From: Anita Gardner
Sent: 27 February 2019 15:12
To: Planning.Responses
Subject: FW: Planning Consultation on FG/11/19/DOC

Site Address: 55 Sea Lane Gardens Ferring BN12 5EG

Description of Works: Application to discharge condition 4 (landscaping) and 9
(Construction Management Plan) in relation to planning application
FG/94/18/PL.

02 Proposed Site Plan
1002 Scale: 1:200

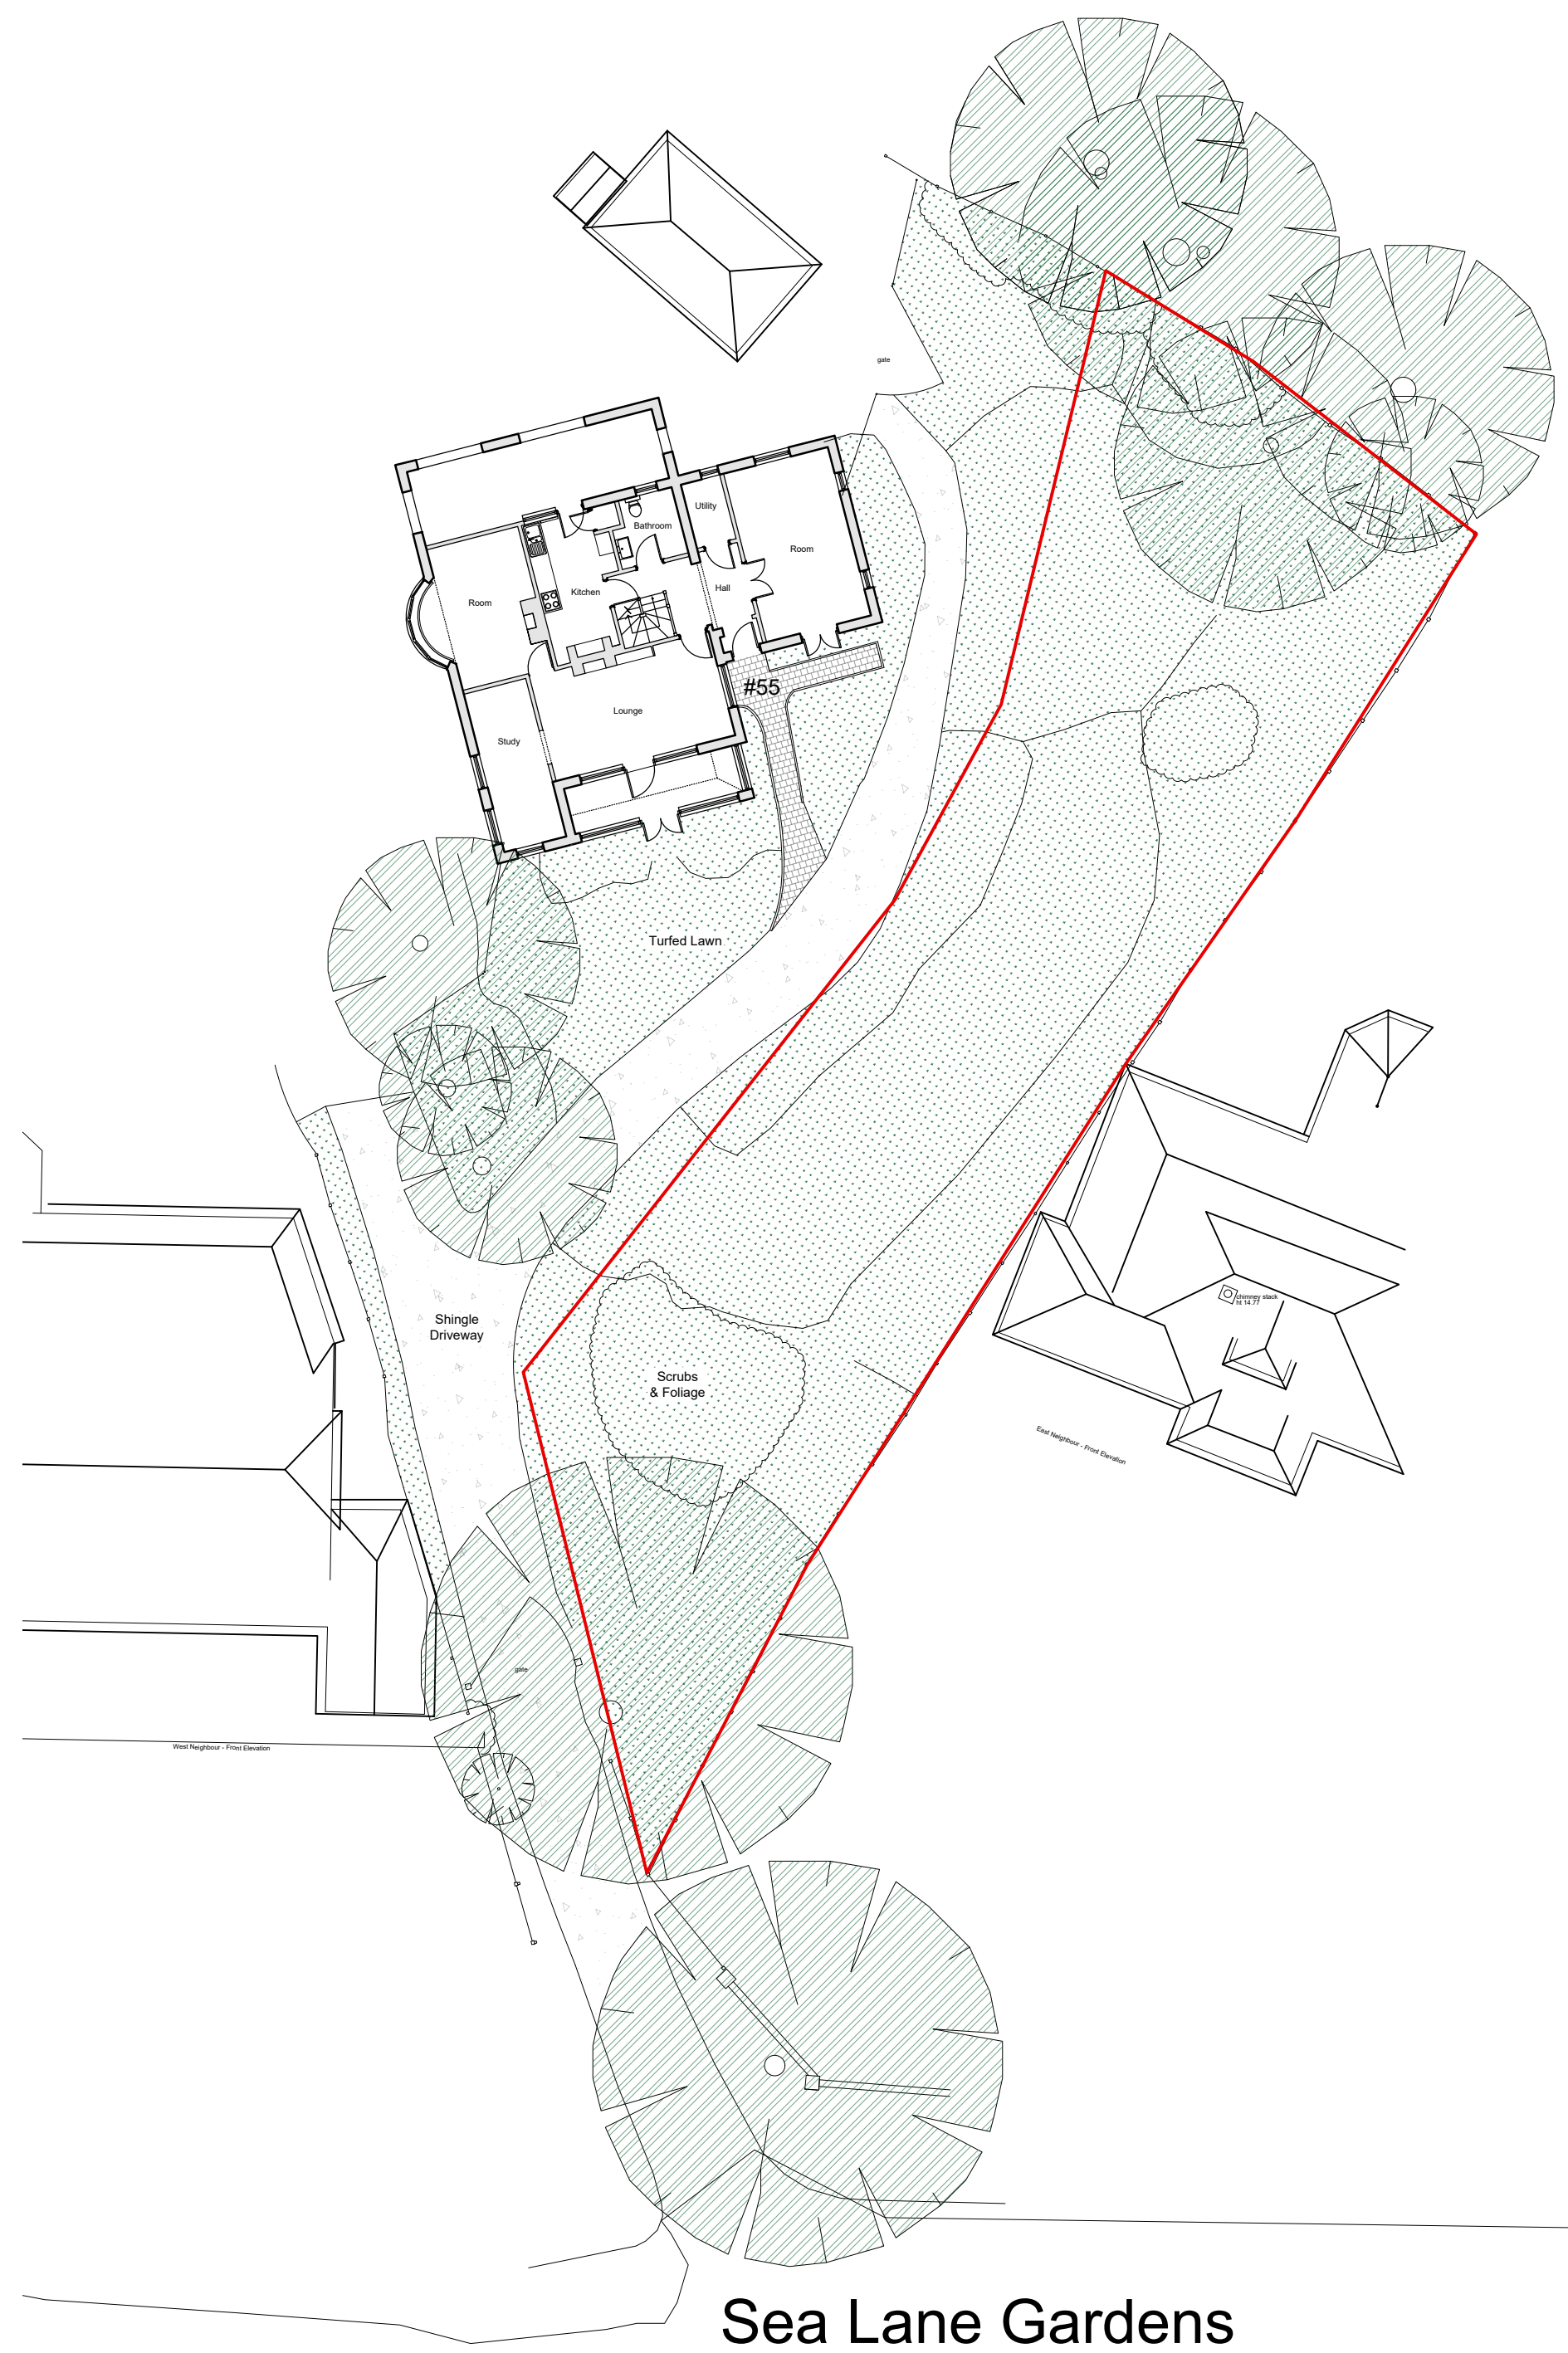
Please see the comments below from the landscape officer. Given her concerns regarding the number of Photinia Red Robin plants proposed I would appreciate your written agreement to increase the plant numbers to 10.

Further to submission of additional information re landscaping, I can confirm that the information supplied is sufficient in detail and that the plant choice is suitable in size and species for location. I would comment that the whilst suitable should be checked on site re quantity (8no proposed) to ensure there are sufficient to effectively plant the areas shown for Photinia planting/hedging Dwg BBF 1002 01 and that they should be adjusted in number accordingly if found insufficient so as to fill the space and form the screening as intended.

I would therefore recommend the discharge of condition 4 on application FG/11/19/DOC imposed under FG/94/18/PL subject to providing the correct quantities required on site, noted above.

My client (Mrs Brooks) agrees to increase numbers of Photinia Red Robin from 8 to 10 as per the landscape officers recommendations.
